RE: Suncadia Ph 3 Div 18 Boundary Line Adjustment (BL-25-00006) - Deemed Incomplete

Parcel #11852 & 16231

Kittitas County Community Development Services received your Boundary Line Adjustment application on April 24, 2025. The application has been determined **incomplete** as of May 6, 2025

JOB NO. 998-847-022-0202 | DATE: 2025-04-17
 DRAWN: C.A.F. | SHEET 1 OF 3

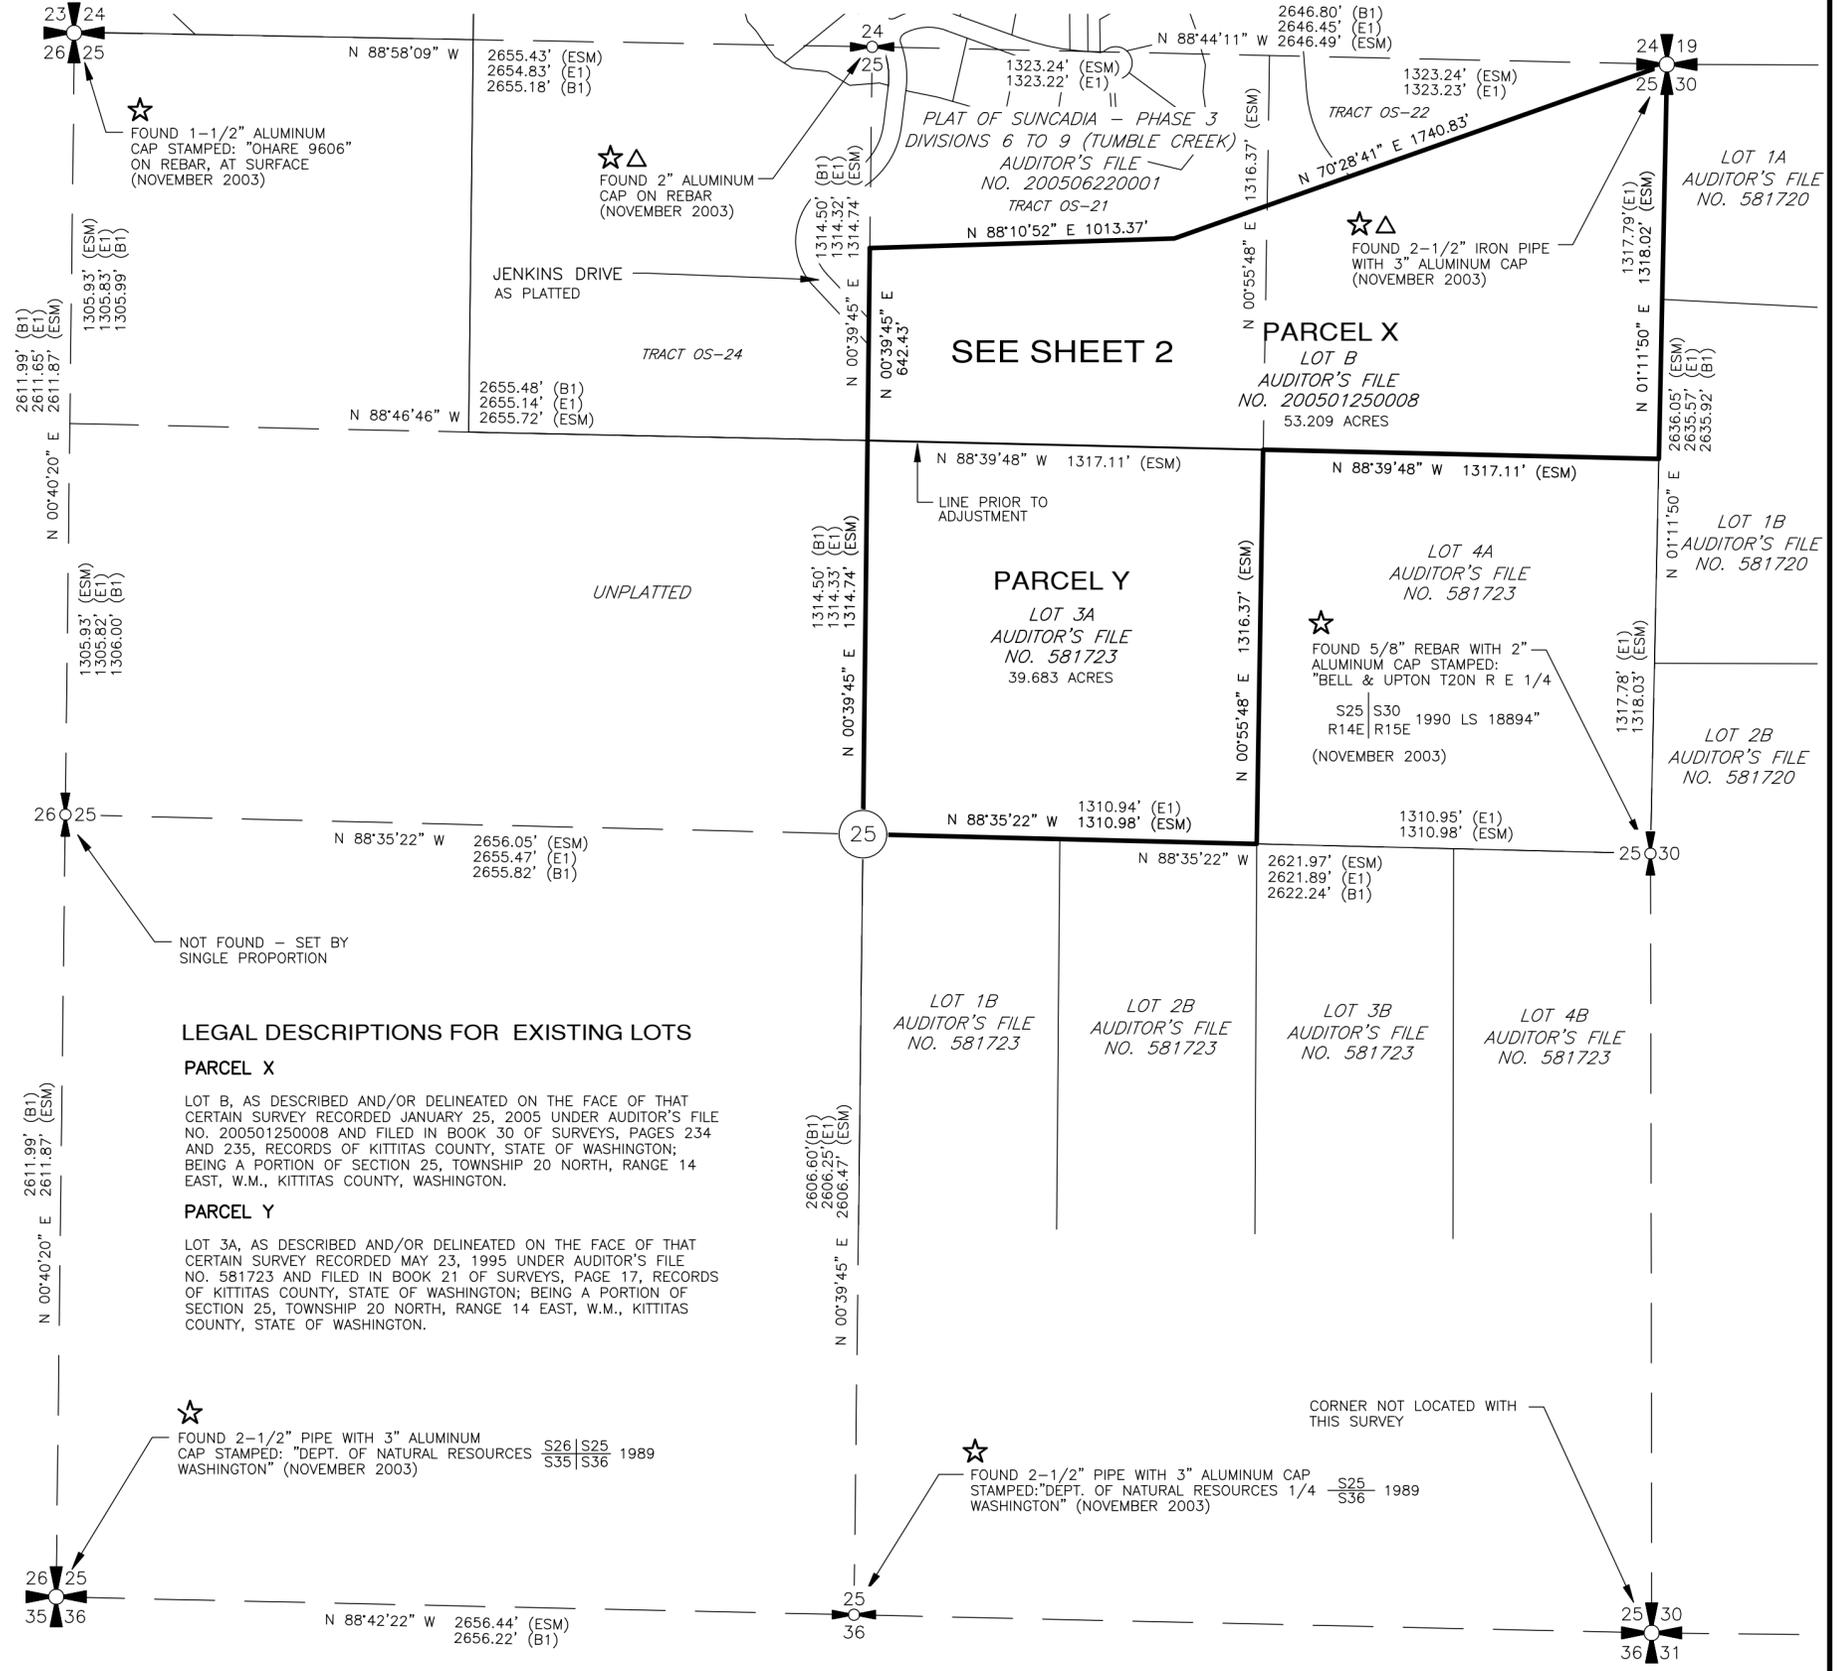
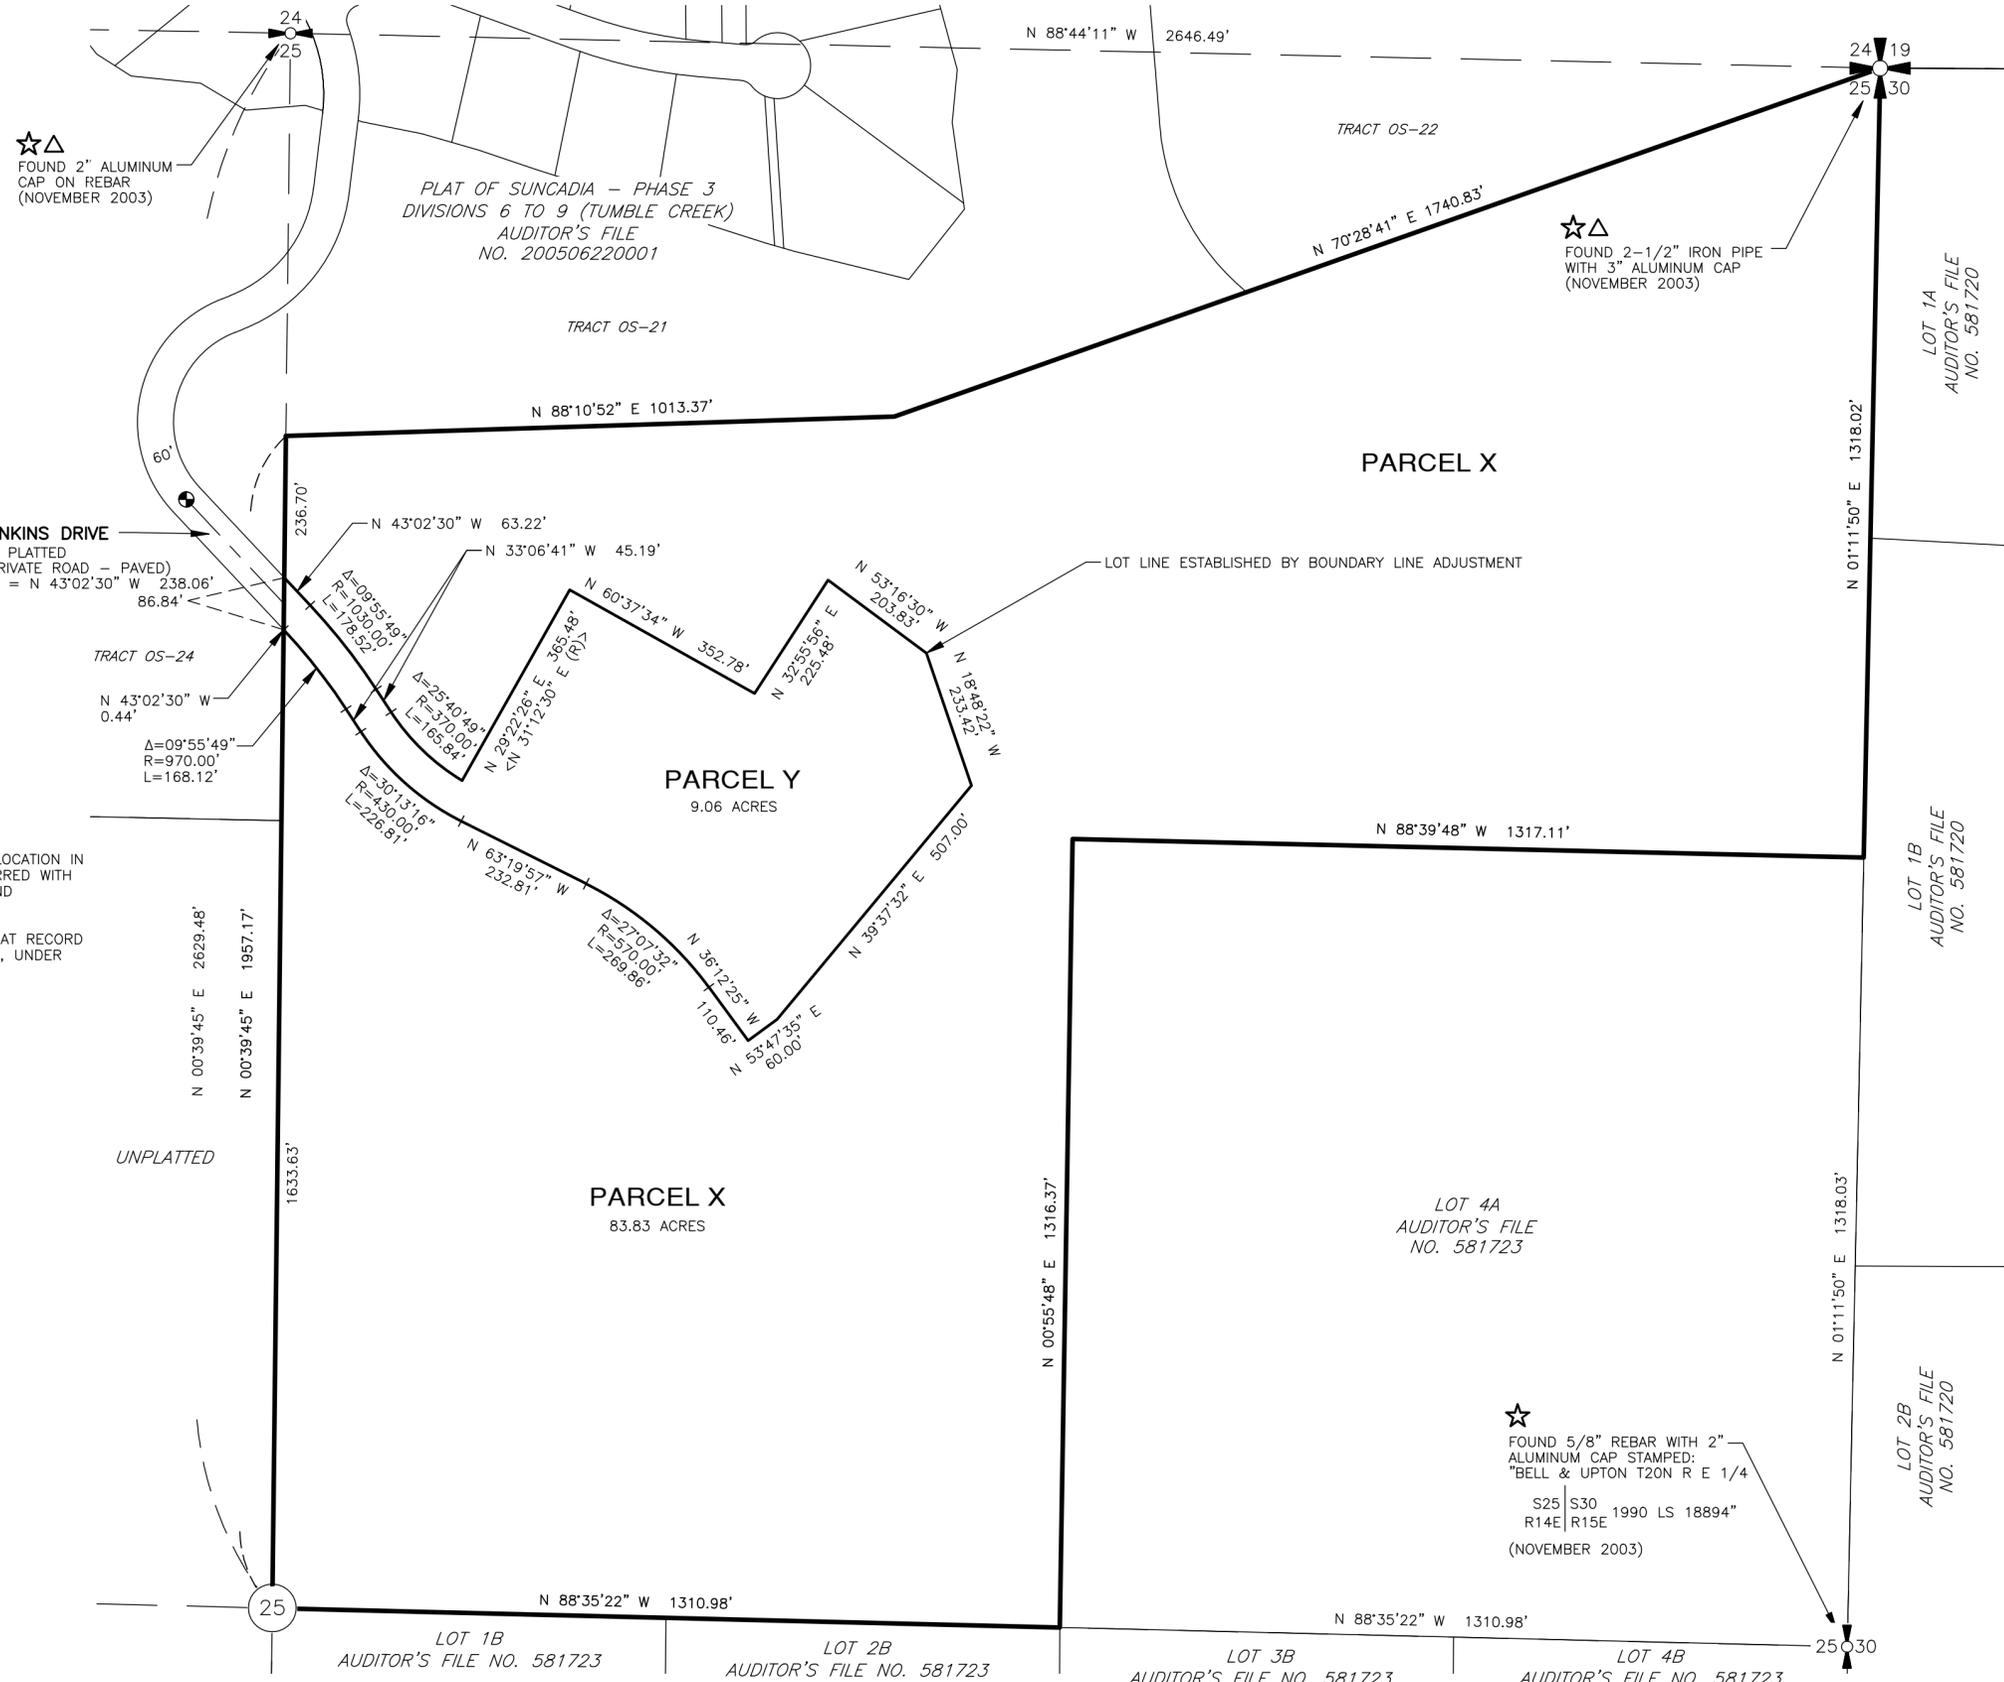
1. The listed new acreage for the boundary line adjustment is inconsistent within the application documents. On the application itself, Parcel X is listed to have 83.53 acres and Parcel Y is listed to have 9.36 acres. However, on the submitted survey & parcel data documents, Parcel X is listed to have 83.83 acres and Parcel Y is listed to have 9.06 acres. Please provide clarification for the intended acreage for Parcel X & Parcel Y.
2. The total acreage pre and post boundary line adjustment does not match. Existing acreage is 92.88 acres and the new acreage listed is 92.89 acres. There is a difference of .01 acres. Please provide adjusted new acreage that totals the existing total acreage, OR provide documentation that proves there is 92.89 acres between these parcels versus 92.88 acres.
